An Bord Pleanála
Strategic Housing Unit
64 Marlborough Street
Dublin 1
D01 V902

Date: 23 May 2022
Our ref: 3237/22/5
Your ref: ABP - 313361

Re: SHD planning application for the construction of a total of 415 No. residential units (252 No. houses, 135 No. apartments, and 28 No. duplex units); with 1 No. childcare facility and ancillary residential amenity facilities, a proposed Strategic Housing Development, on lands at Back Road & Kinsealy Lane, Kinsealy, Broomfield, Malahide, Co. Dublin.

DRAWN RW	DESIGNED RW	APPROVED MD	DATE NOV '20
SCALE AS SHOWN @ A1	JOB NO. 18-091	DRG. NO. P210	REVISION A

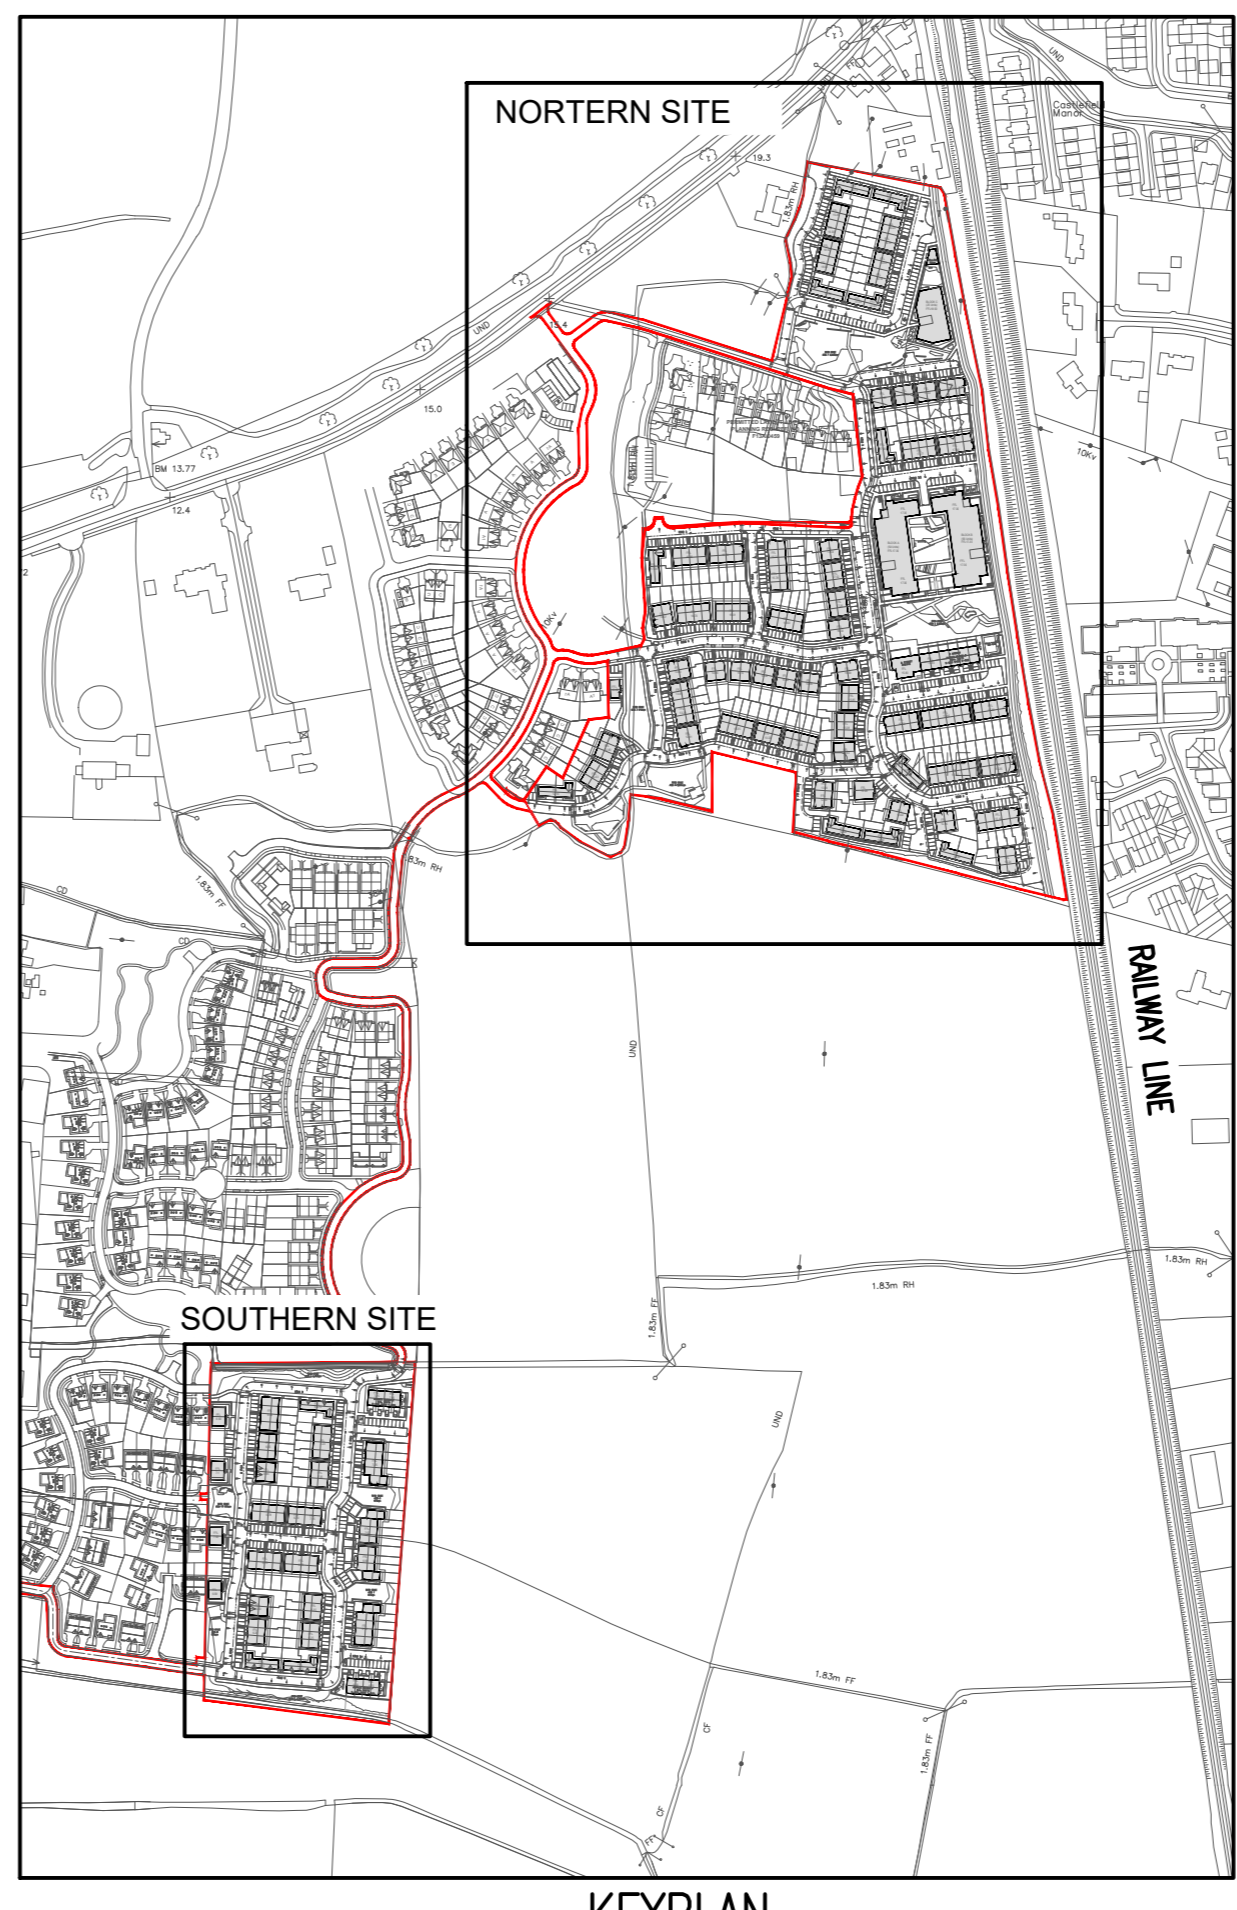
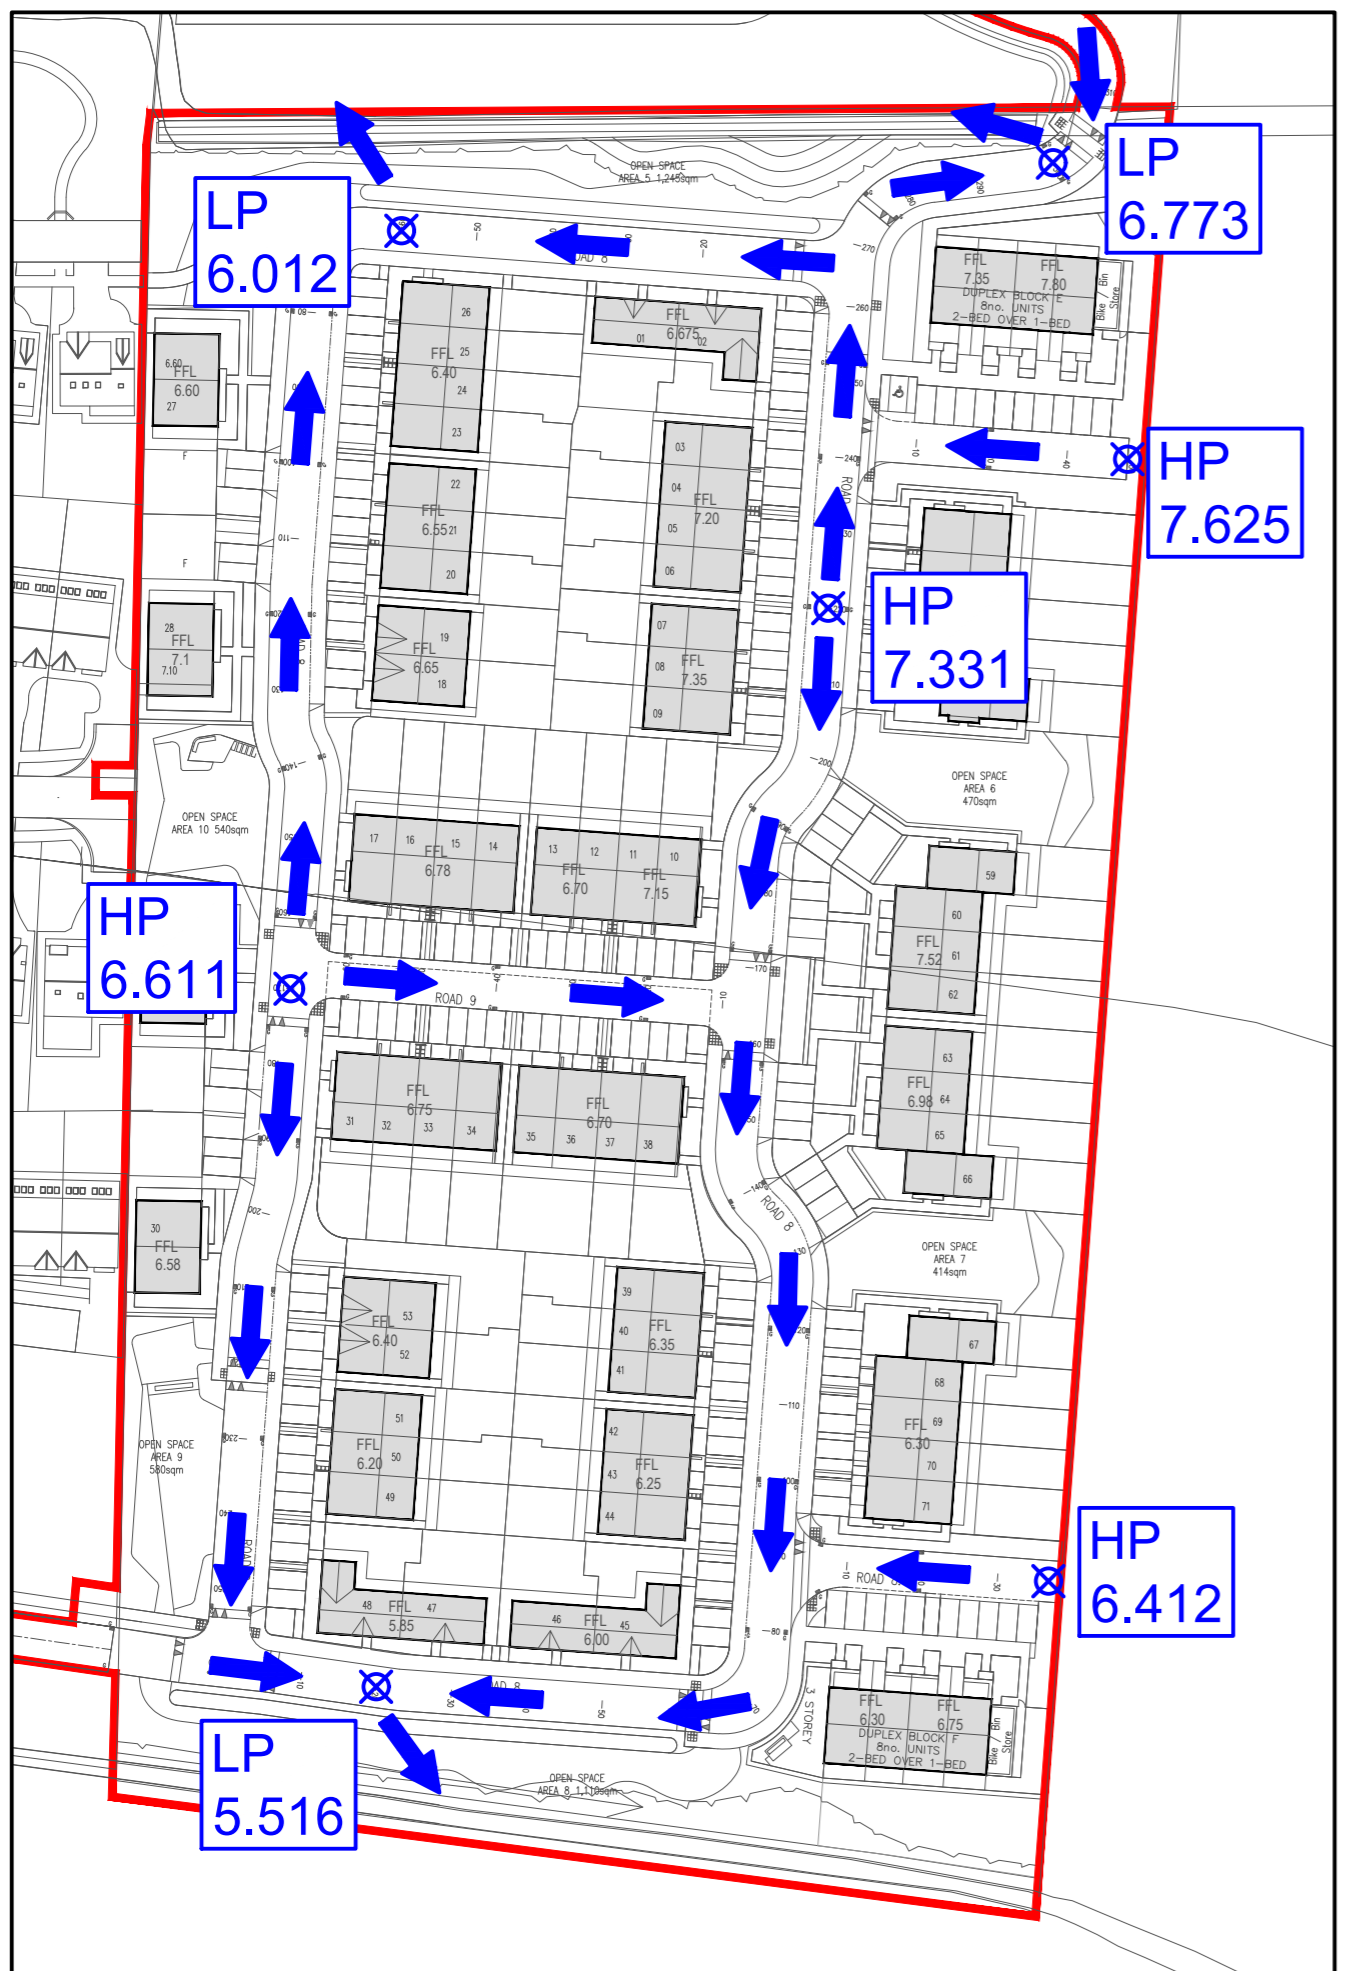
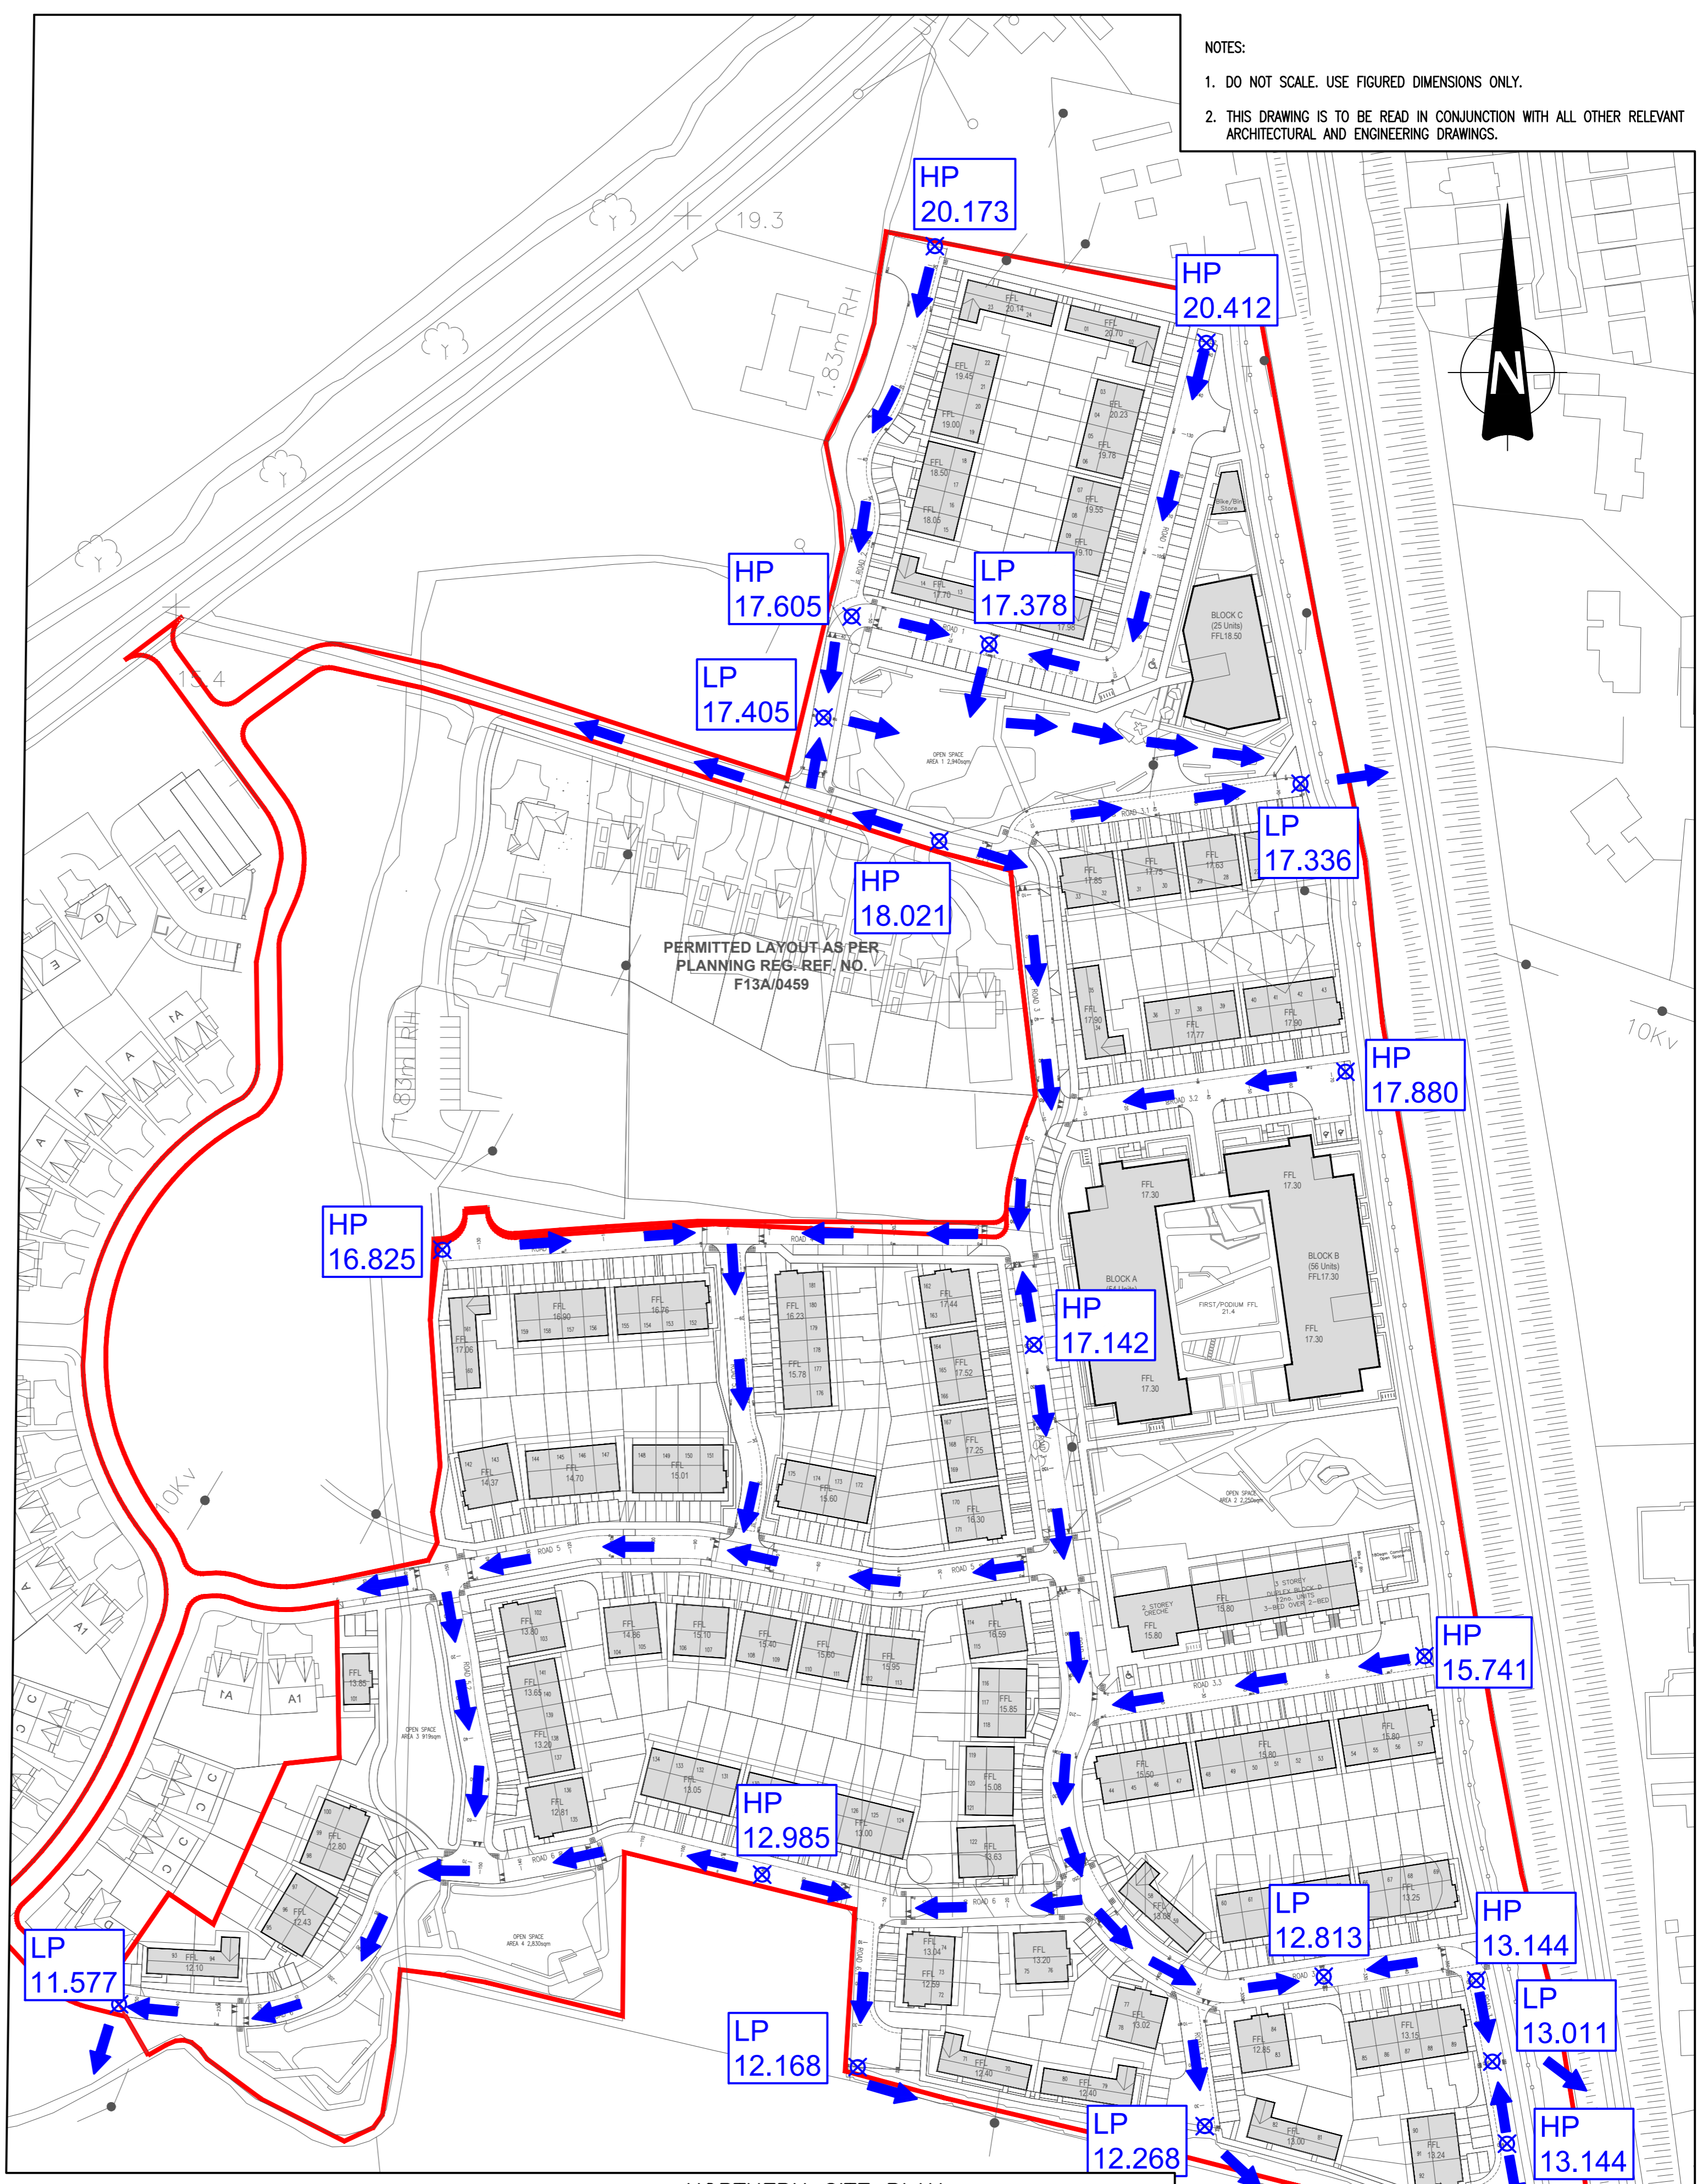
- 13) It is noted that due to the proposed increase in hardstanding areas adjacent to the track that there is an increased 'moderate' risk of overland flooding from the development site. It is noted that the proposed overland flood routing proposes overland discharge onto the track in three separate locations as indicated in Section 3.6 of the Waterman-Moylan Flood Risk

Assessment Report. Under no circumstances should any additional liquid, either surface water or effluent be discharged to, or allow to seep onto, the railway property or into railway drains / ditches.
